February 5, 2015

Re: Civic Center Signage Master Plan, Second Amendment
Project ID: #2012-505

Original fixed signage location to be replaced with new Cross Insurance Arena Sign

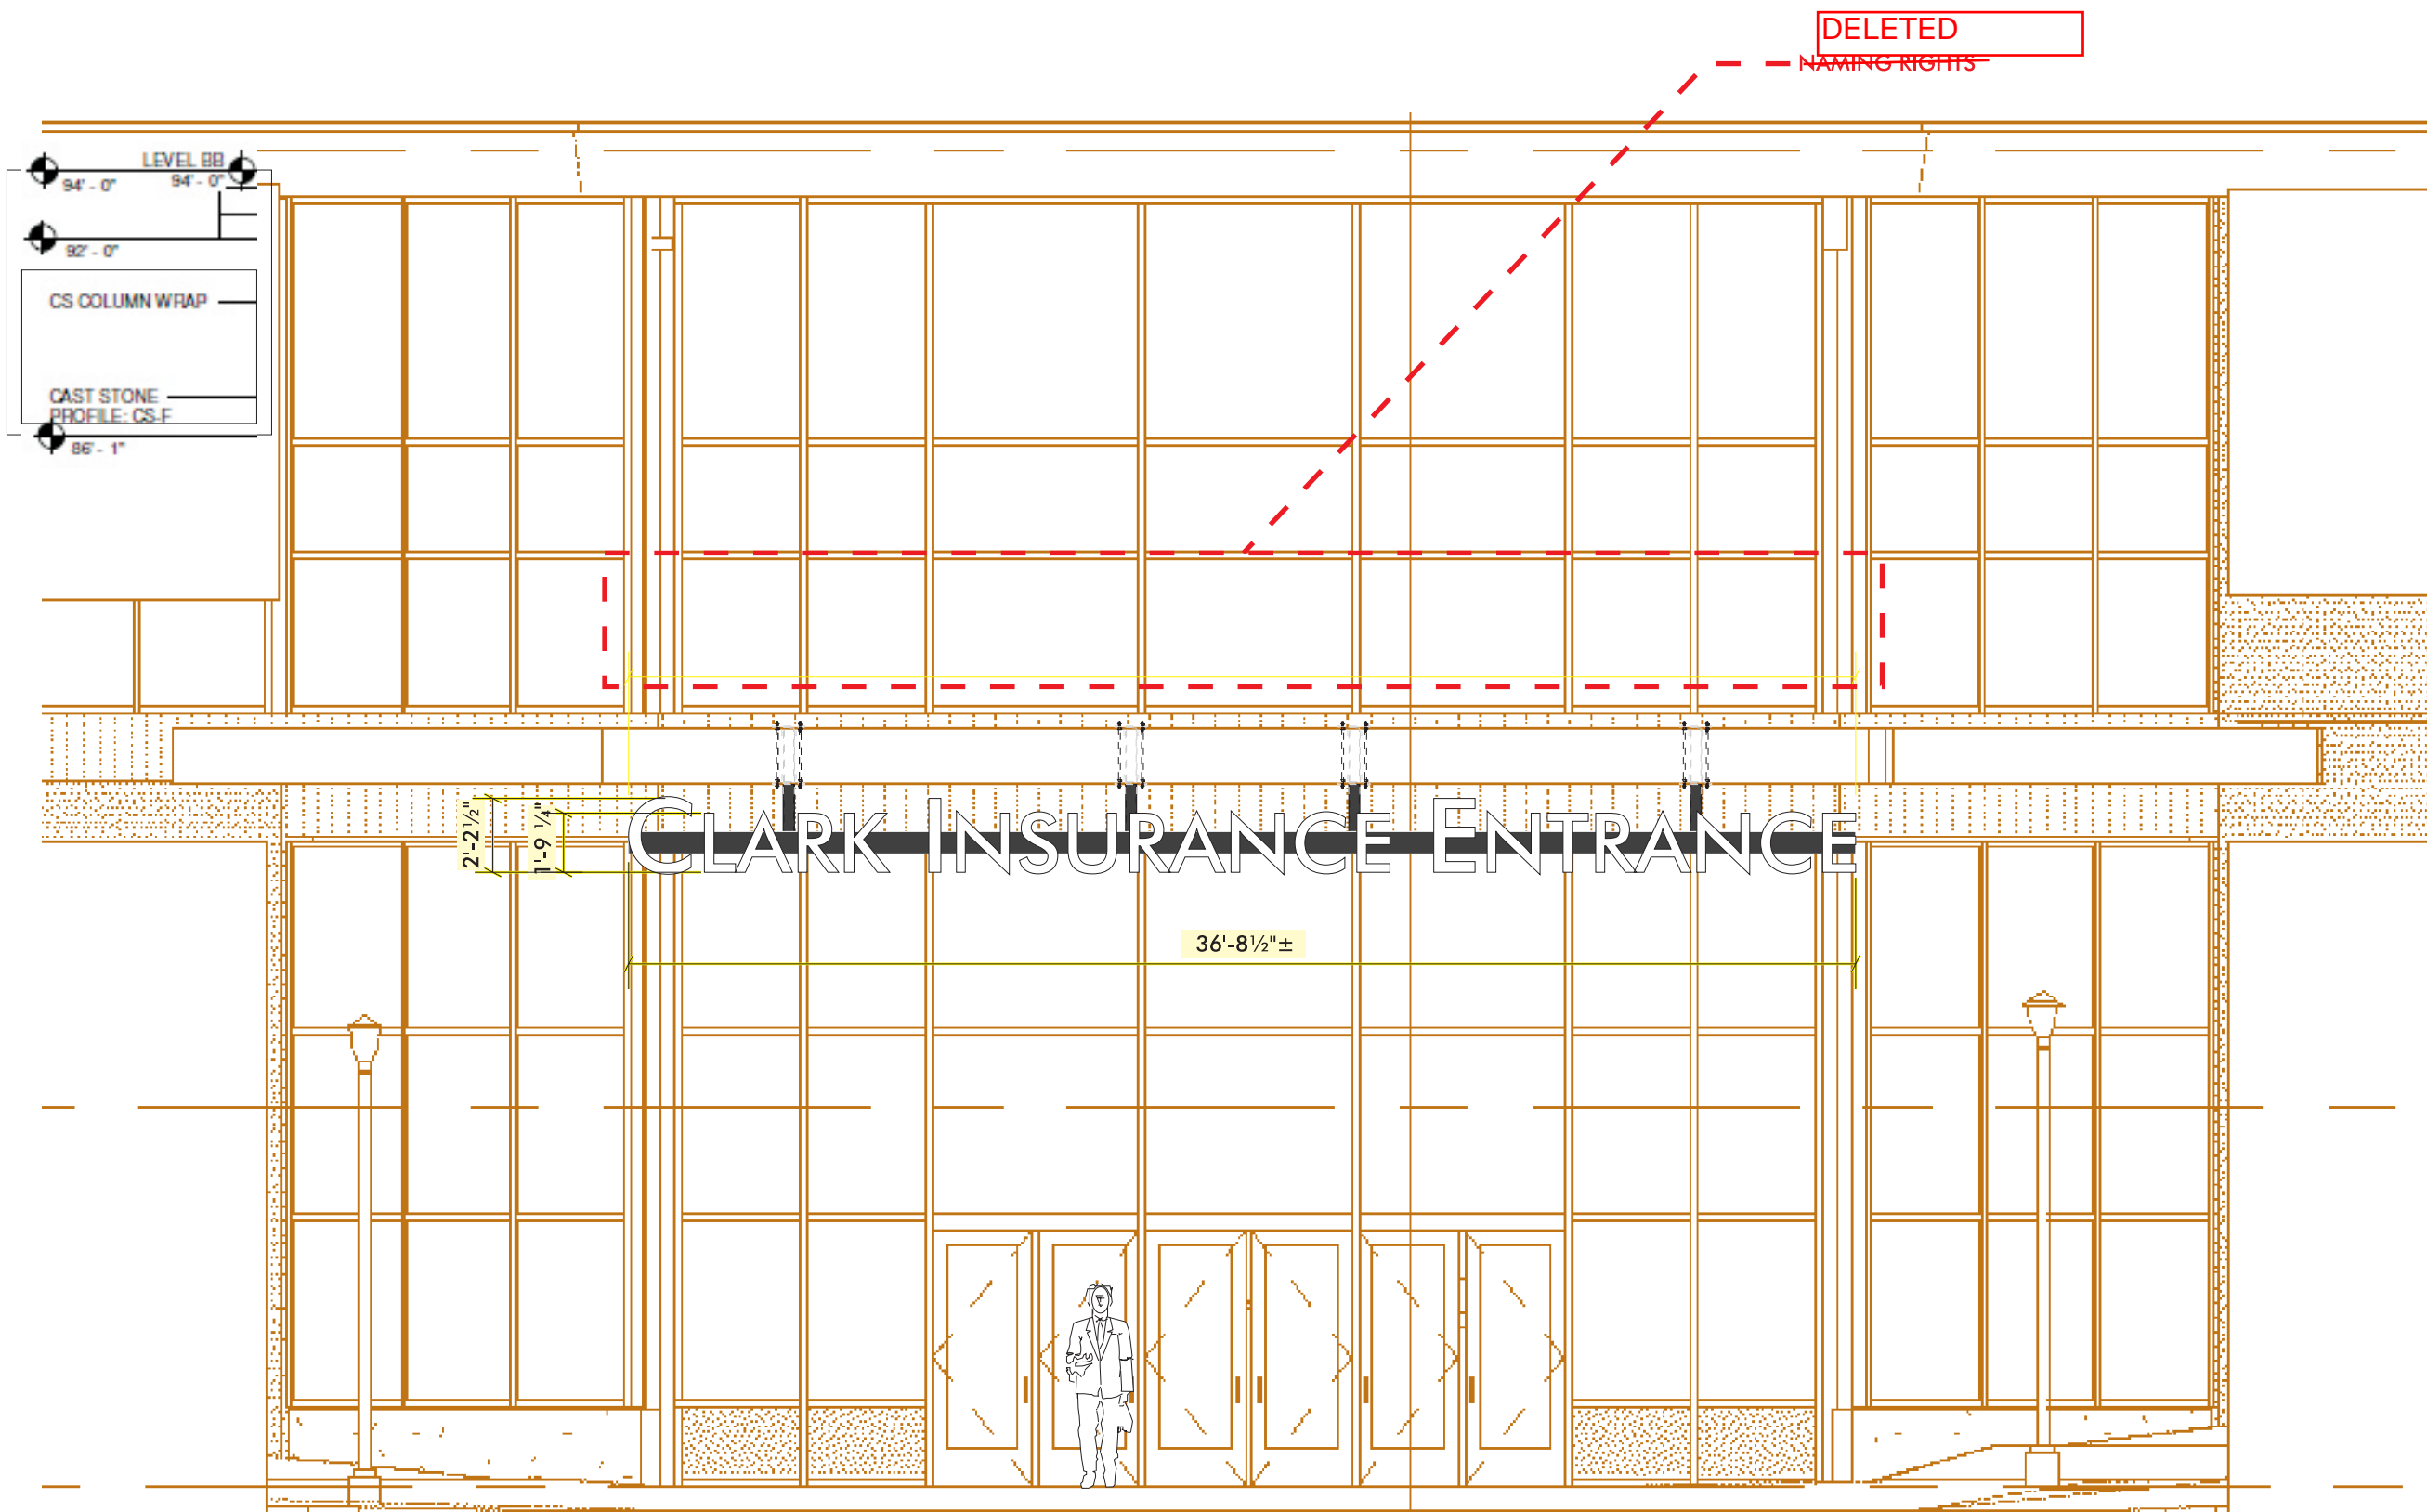
Specifically you are requesting to replace a sign proposed above the proposed marquee on the southeast entrance of the Civic Center with a sign on the southeast side of the building, where the current Cumberland County Civic Center sign is located. You propose to retain a sign of the same size at that location, with the new name of the building and a lighthouse. While the name of the arena is the Cross Insurance Arena, you are not proposing using the Cross Insurance logo at that

You are not proposing a sign above the cornice of the building, nor are you proposing a sign any larger than the one already located at that location. The number of signs remains the same based on the removal of the proposed sign at the southeast entrance, which, while smaller in size, would be visible from a similar direction.

For these reasons, I approve that substitution with one condition. The metal band on which the marquee is eventually proposed for the southeast entrance will need an interim treatment while the plans to install a marquee are completed. Please submit a plan for an interim treatment for that metal band for Planning Authority review and approval under the master signage plan.

Attached is a revised master signage plan reflecting these changes. Please let me know if this revised plan is not accurate. I wish the Cross Insurance Arena success.
